**RE: Goodwill at 270 98<sup>th</sup> St NW  
Erosion and Sediment Control Plan  
Engineer's Stamp Date 9/13/24 (K09E048E)**

Based on the information in your submittal received on 9/14/24, and Scooter Haynes resubmittal on 10/16/24, the ESC plan cannot be approved until the following comments have been addressed.

| Sheet: EROSION CONTROL PLAN |                 |

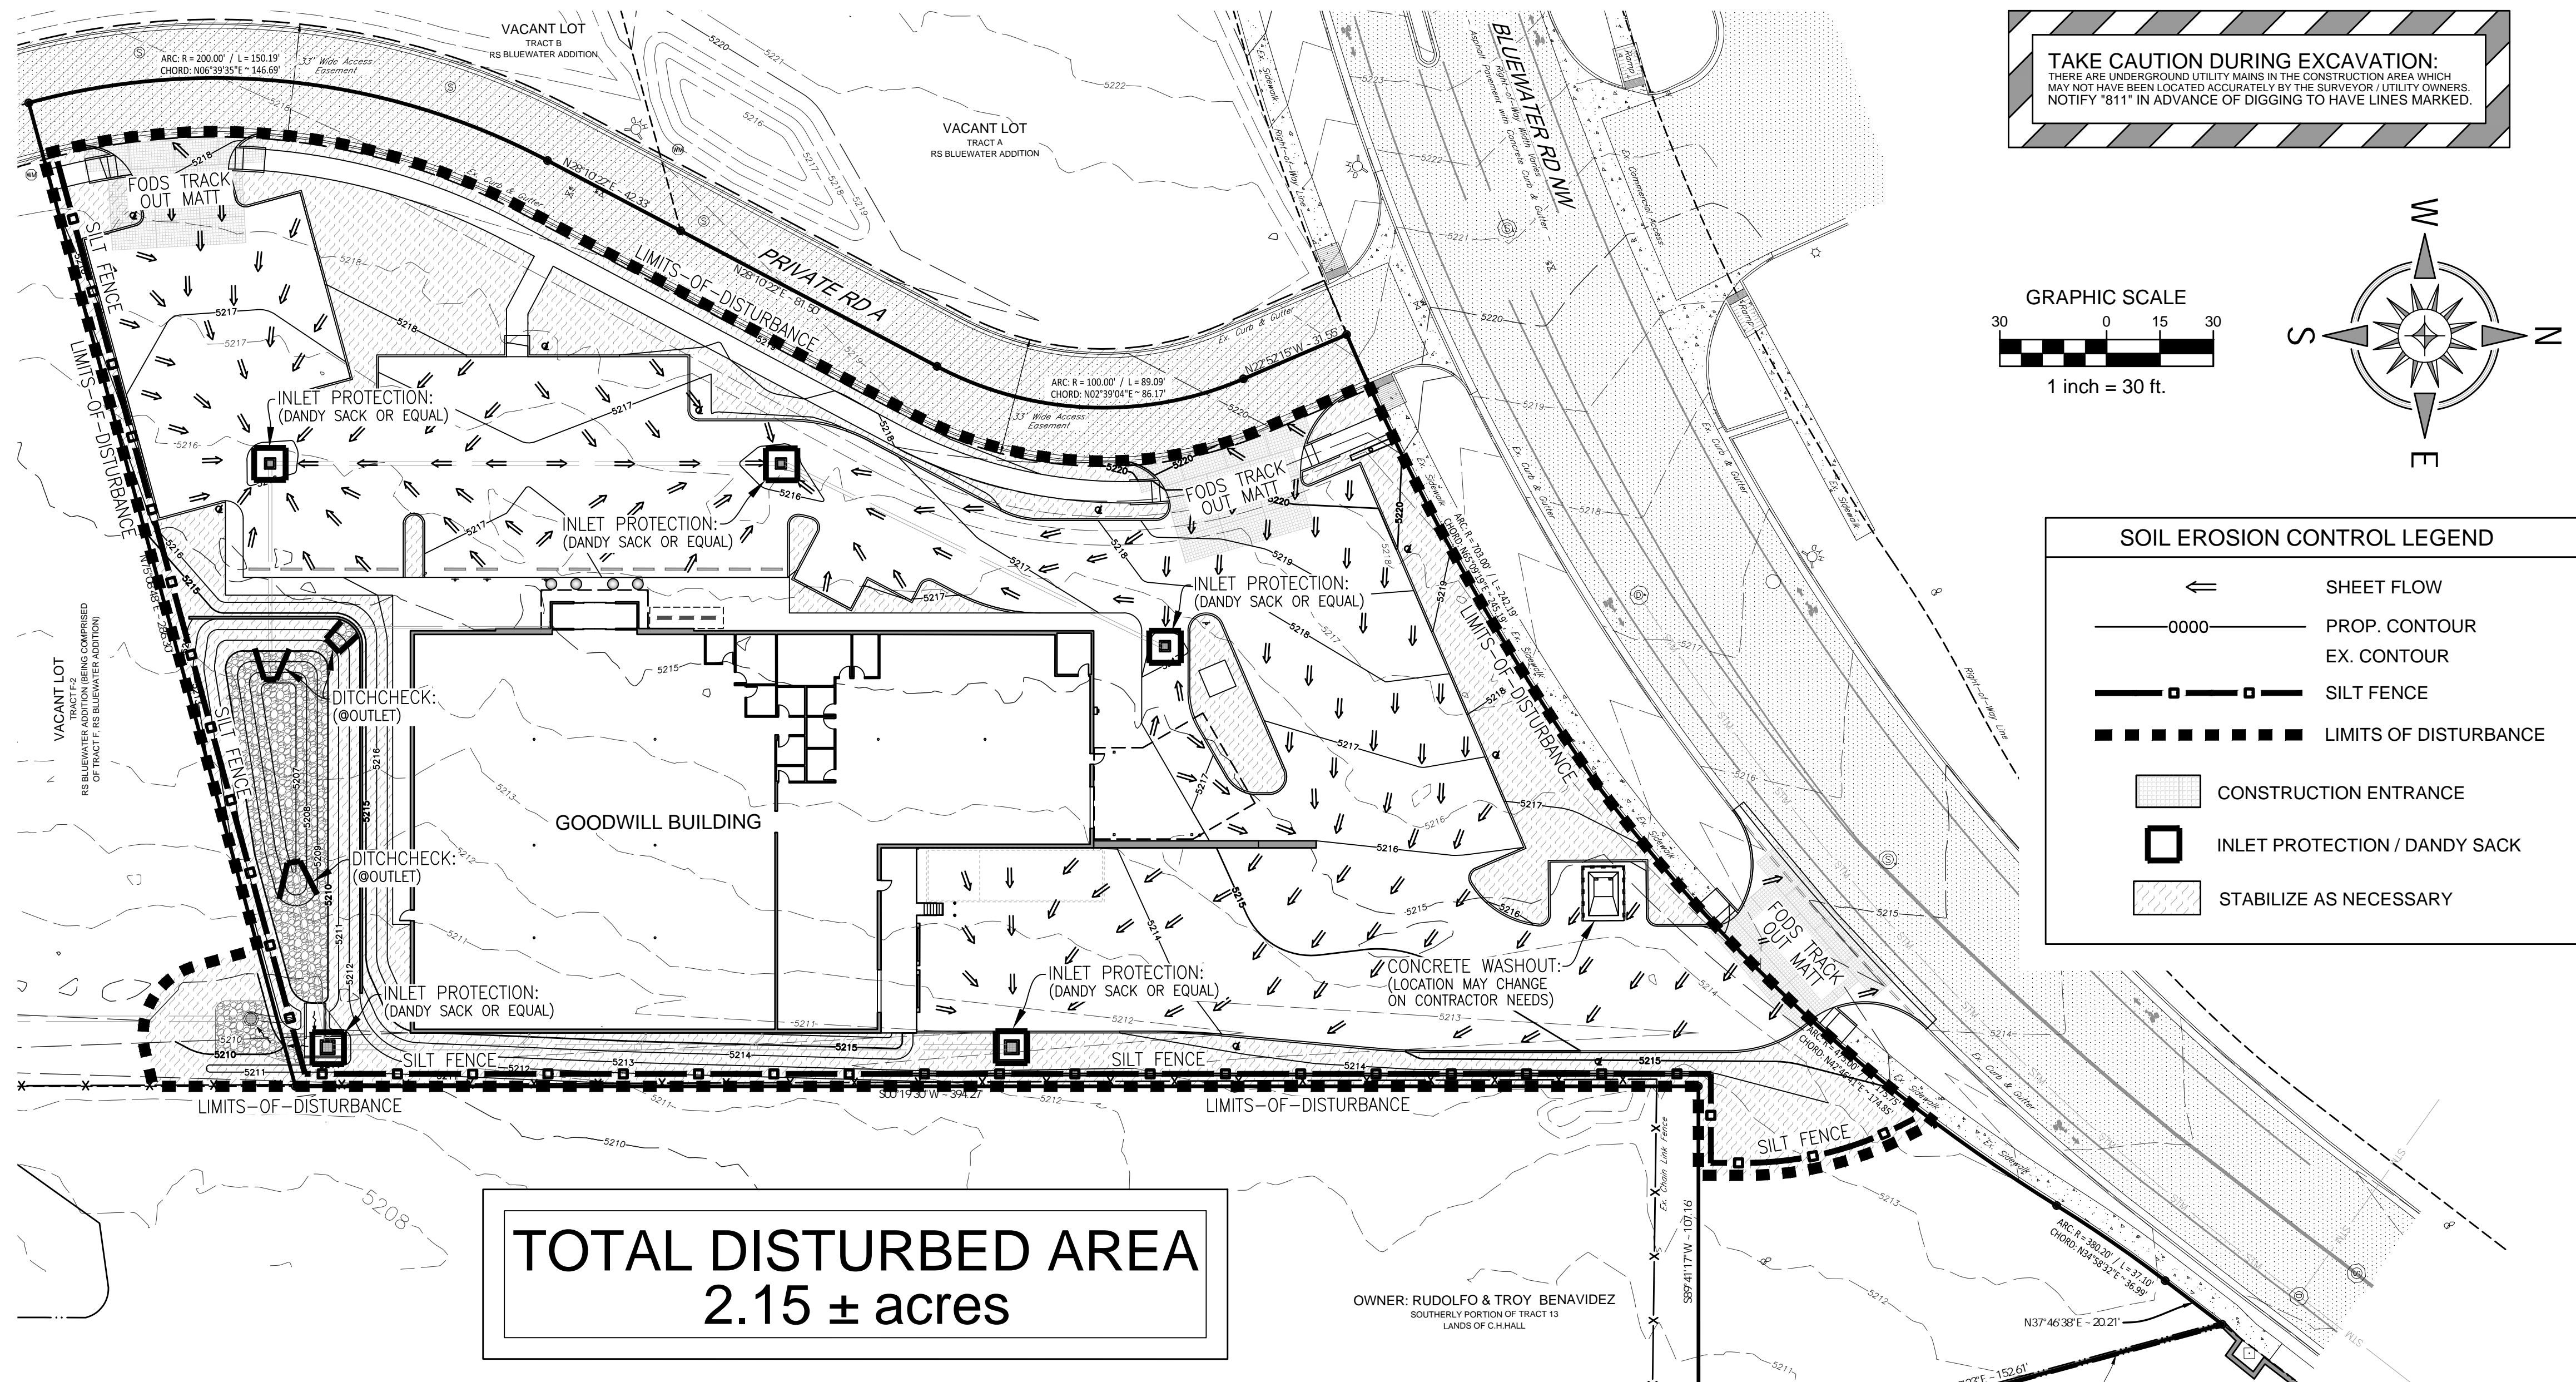
1. This site's only allowed stormwater discharge location is concentrated flow from the southeast corner. Silt Fence (SF) isn't adequate for concentrated flow, so you must provide diversion berms/swales (DV) along the low edges of the site to direct stormwater into a Sediment Basin (SB) or Sediment Trap (ST) per CGP 2.2.12 in addition to the SF.

- a. Design the basin or impoundment to provide storage for either:
    - i. The calculated volume of runoff from a 2-year, 24-hour storm or
    - ii. 3,600 cubic feet per acre drained.

- b. Utilize outlet structures that withdraw water from the surface of the sediment basin or similar impoundment unless infeasible.
  - c. Use erosion controls and velocity dissipation devices to prevent erosion at inlets and outlets.

- d. Remove accumulated sediment to maintain at least one-half of the design capacity and conduct all other appropriate maintenance to ensure the basin or impoundment remains in effective operating condition.

Include the following information for the SB or ST in your resubmittal.

- e. Specific location of the basin, including dimensions.
- f. Plan view of the storage basin and emergency spillway, showing existing and proposed contours.

- g. Add a bold note at the pond saying, "the pond may not be removed until the rest of the construction is complete and the site is stabilized."
- h. Cross section of dam, principal spillway, emergency spillway, and profile of emergency spillway with elevation specifications for each.

- i. Hydraulic capacity calculations and construction specifications for the principal pipe outlets.
- j. Runoff calculations, 24-hr volume, and peak flow rate for 2-year, 10-year, and 100-year frequency storms assuming the densest impervious cover that will occur during construction.

- k. Hydraulic capacity calculations and construction specifications for the emergency spillway if the primary outlet won't pass the 100-year flow.
- l. Storage computations

- m. Sediment volume required (& calculations)
- n. Sediment volume available, cleanout elevation, and depth below the primary outlet.

Sheet: EROSION CONTROL NOTES & DETAILS

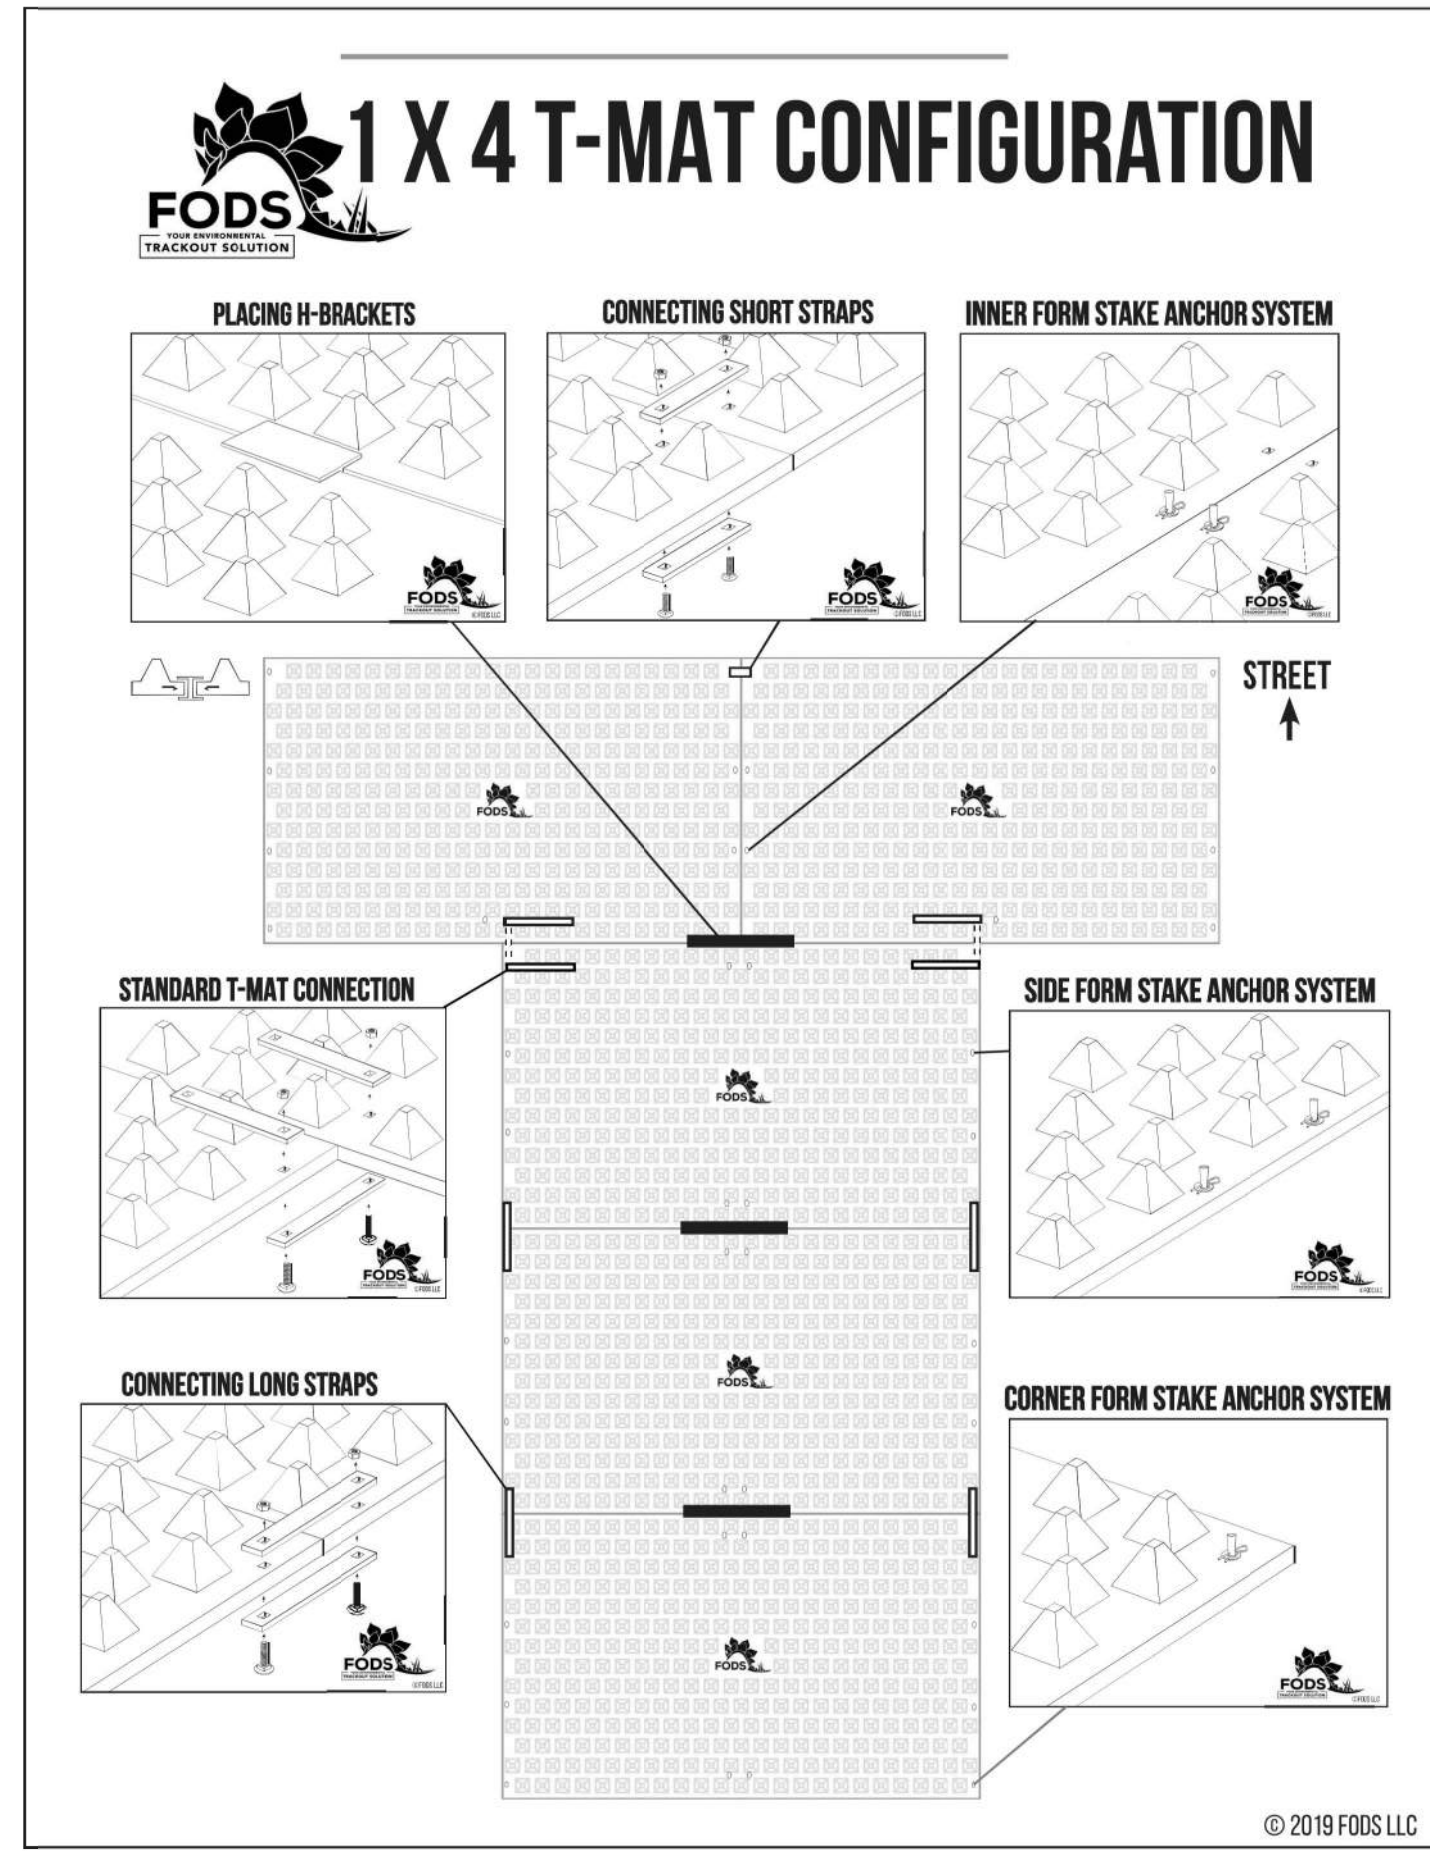
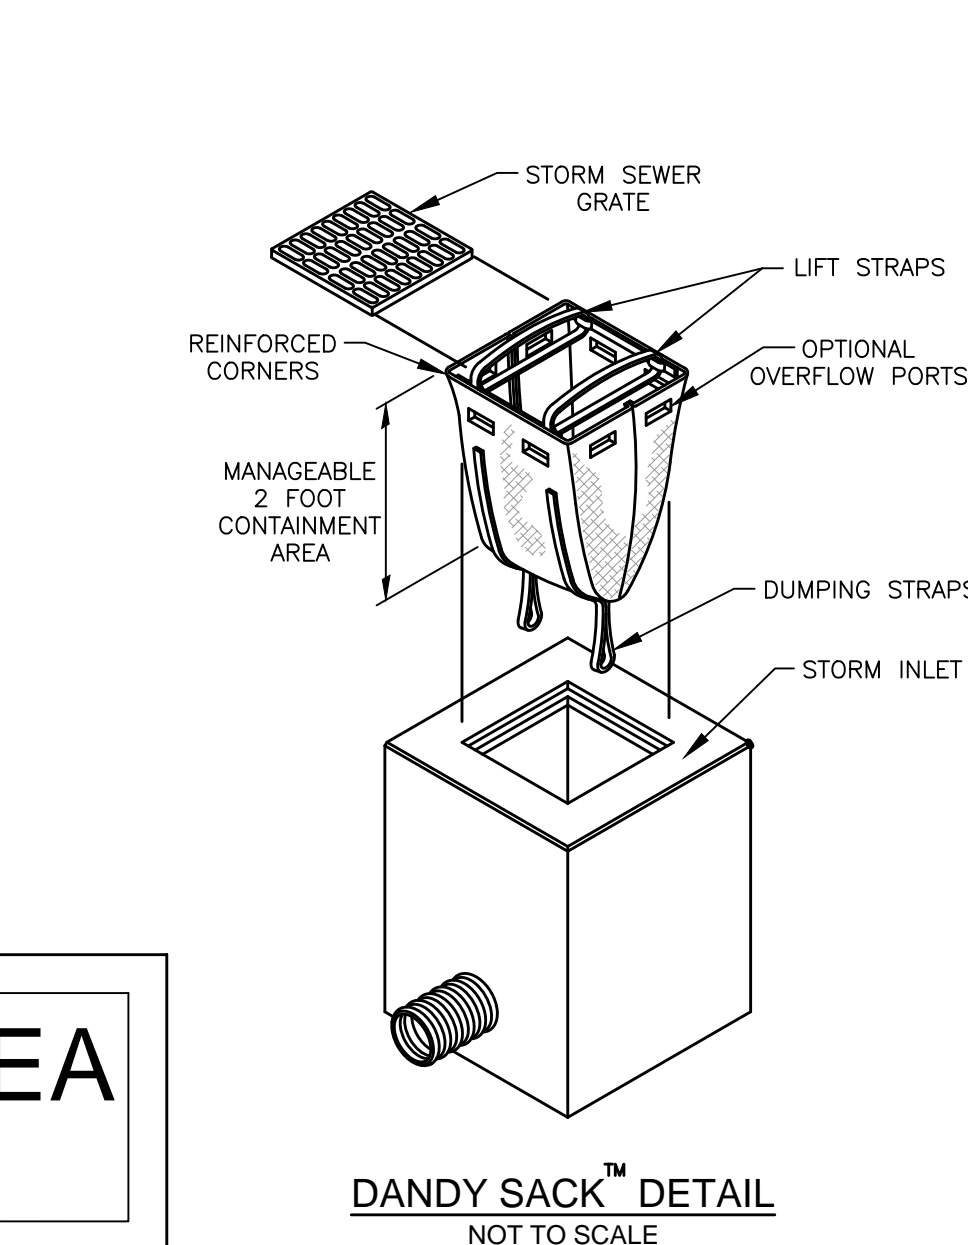
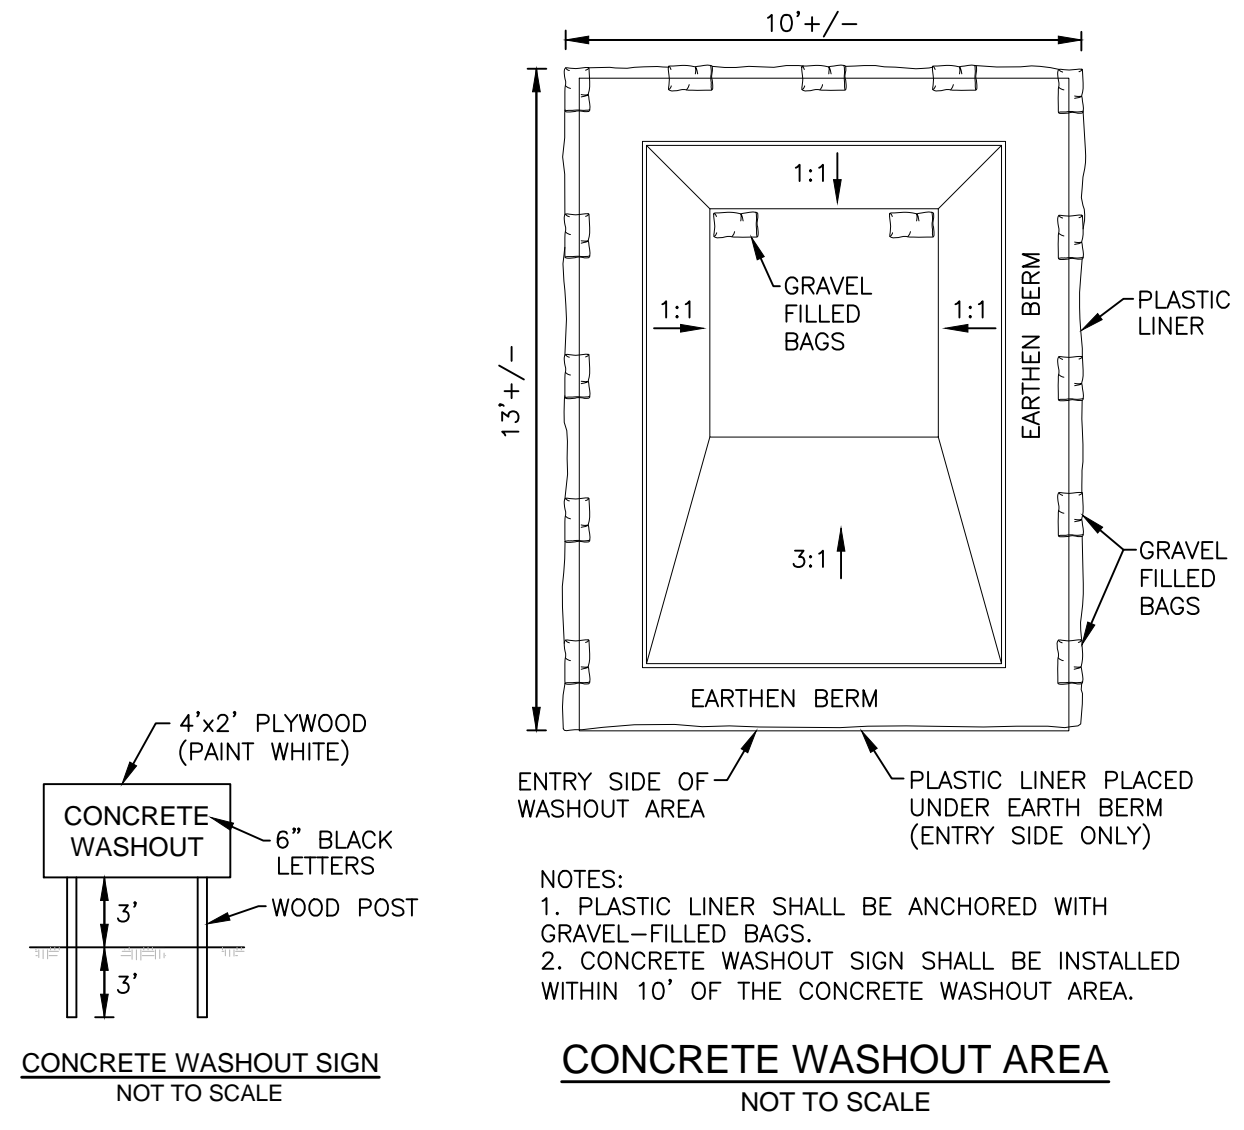
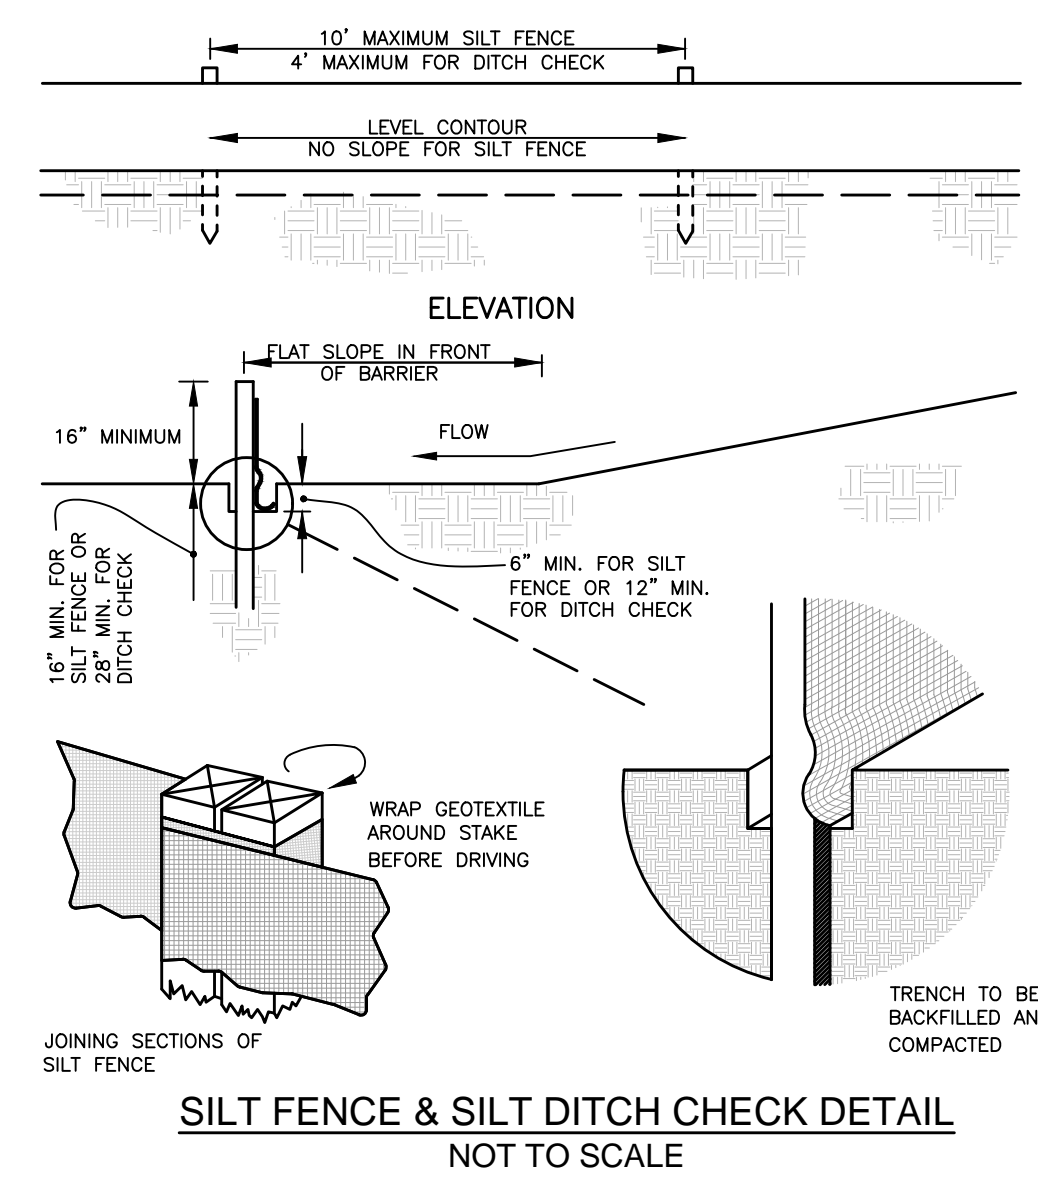
2. Construction details and specifications for DV, SB, and ST are missing and must be added to the Detail sheet per CGP 9.6.1.c.i.
3. The SWPPP must include site-specific interim and permanent stabilization per CGP 9.6.1.c.i. The Landscape Plan can be used to satisfy this requirement and should be submitted separate from the ESC Plan with the application to the Stormwater Quality Section of the Planning Department and they should be included in the SWPPP. Provide specifications on the ESC Plan for any disturbed areas not covered by the Landscape Plan.
4. Replace the City Standard Notes with the current version (attached).
5. Update the engineer's stamp date each time the plan changes.
